Drainage Summary Report

Desert Willow Family School

February 17, 2017

**RE: APS Family School East Side
3303 Monroe St NE
Drainage Plan and Report
Engineer's Stamp Date: 1/30/2017 & 12/12/2016
Hydrology File: G17D019A**

E4 WIER DETAIL
SCALE: 1" = 4'-0"

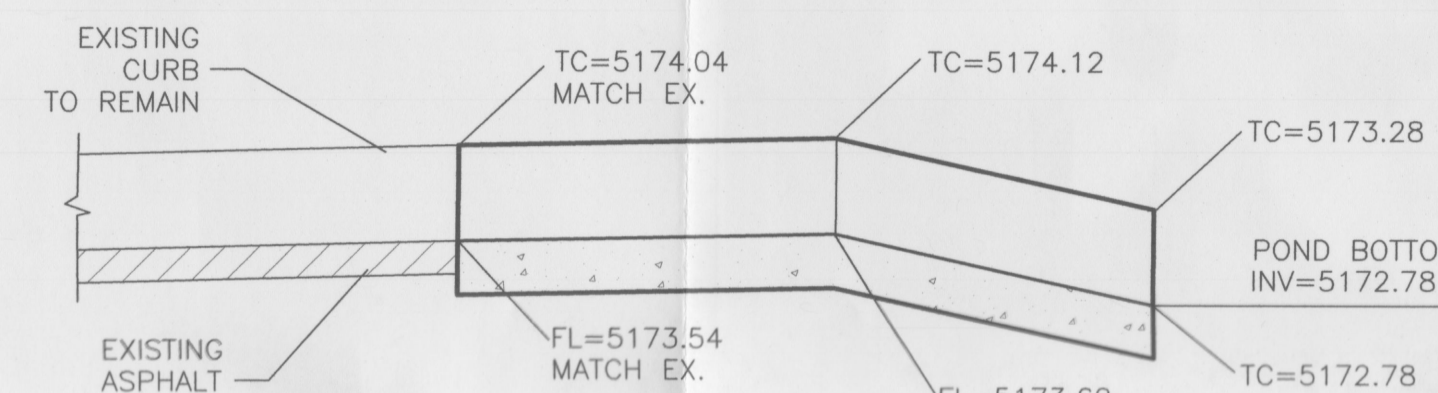
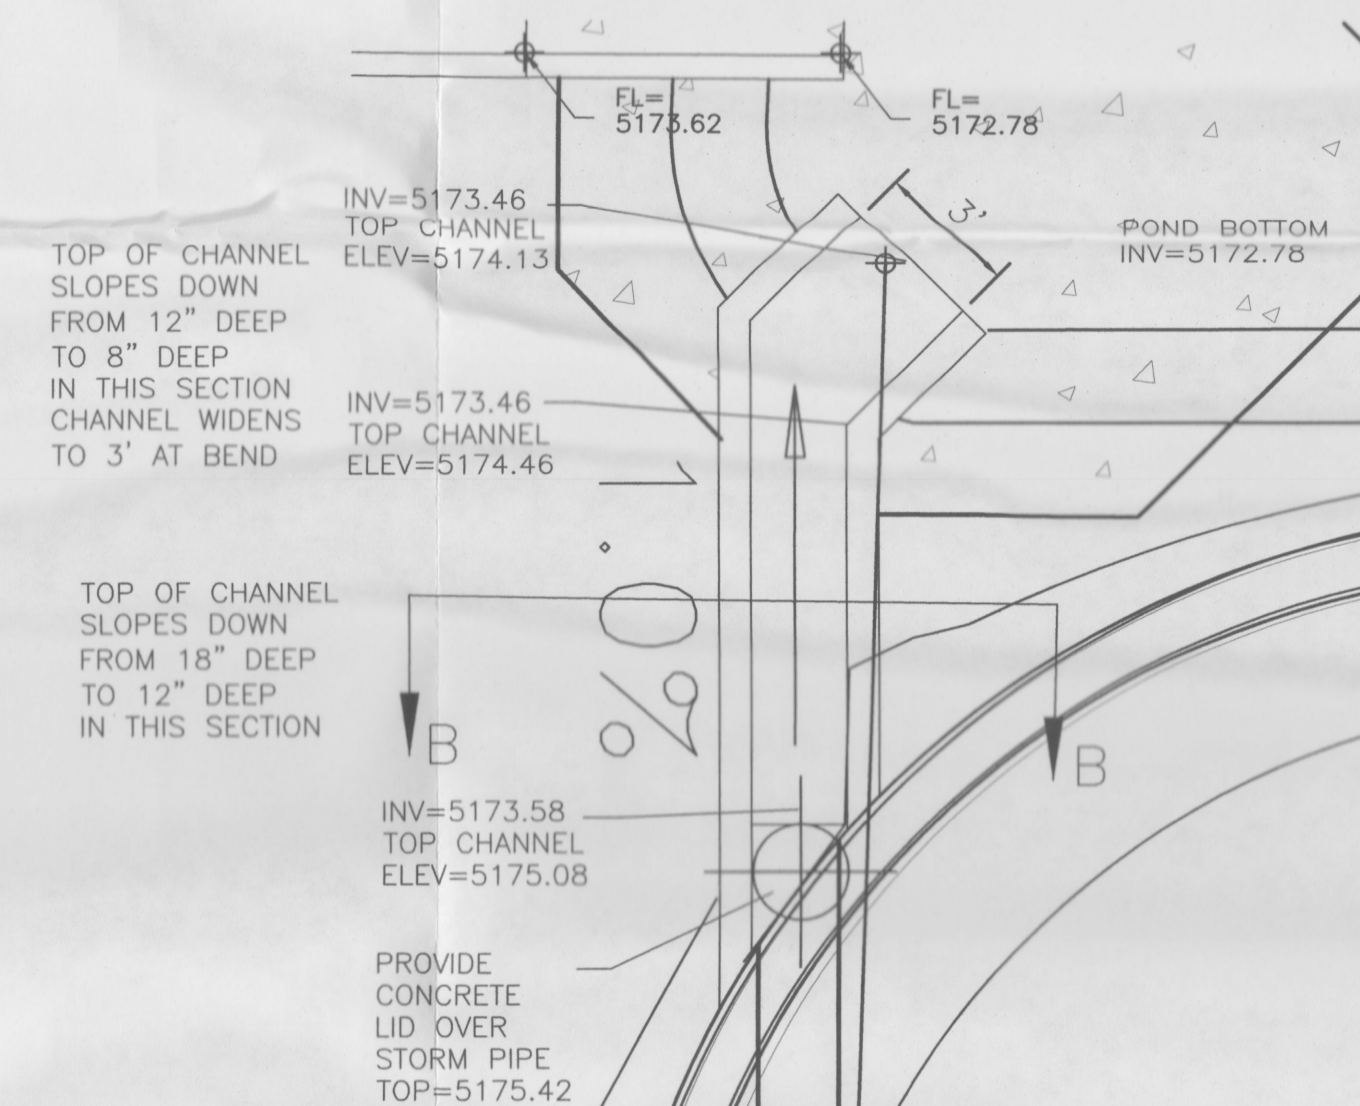
1. Use RVP Class IV underneath the building and the wall
2. Call out Section and detail views for the weir
3. Correct invert elevation on SD Manhole #2

D6 CHANNEL TO PIPE CONNECTION
SCALE: 1" = 4'-0"

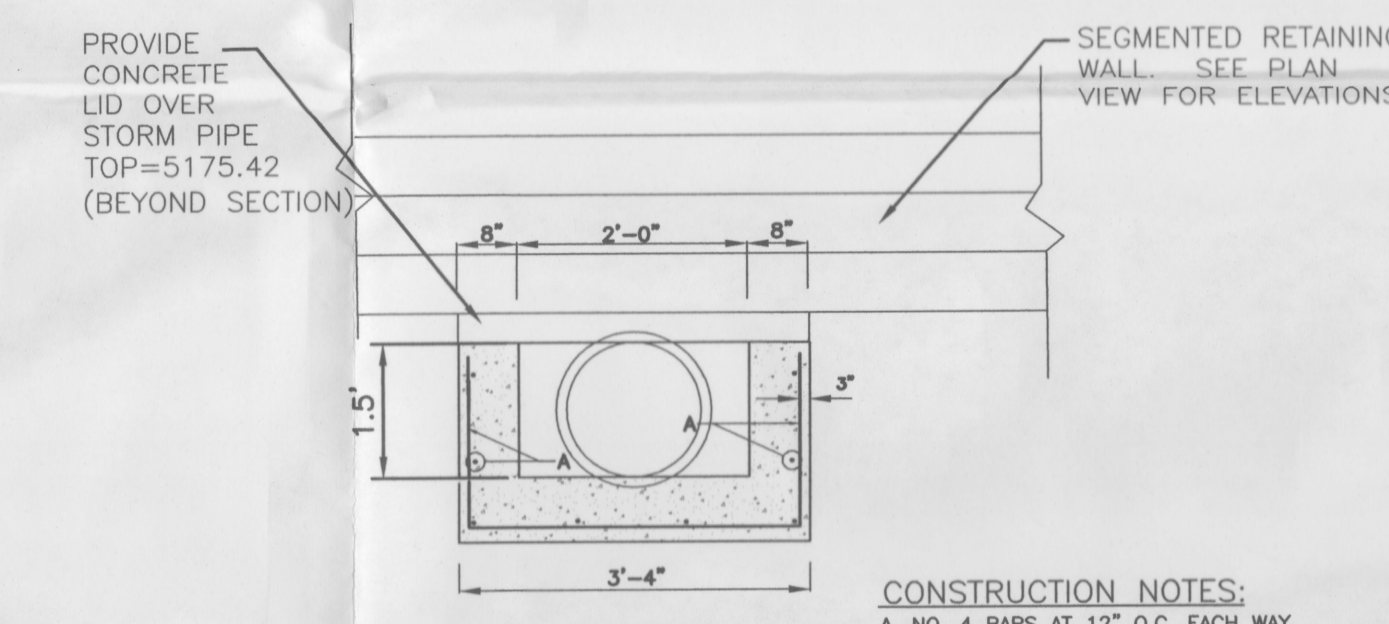
1. Define the limits of construction and provide area. Submittal of an erosion and sediment control plan is required prior to building permit approval if the disturbed area is over 1 acre. Please contact Curtis Cherne P.E at 924-3420 for question regarding ESC plans.
2. Clarify how the storm drain outfalls through the wall and into the pond with a detail view/notes and include dimensions and inverts. In your previous submittal, this information was added for the overflow weir, but not the storm drain outfall.

1. Define the limits of construction and provide area. Submittal of an erosion and sediment control plan is required prior to building permit approval if the disturbed area is over 1 acre. Please contact Curtis Cherne P.E at 924-3420 for question regarding ESC plans. *Area disturbed = 43,658. Plan submitted to Mr. Cherne.*
2. Clarify how the storm drain outfalls through the wall and into the pond with a detail view/notes and include dimensions and inverts. In your previous submittal, this information was added for the overflow weir, but not the storm drain outfall. *Details Added.*
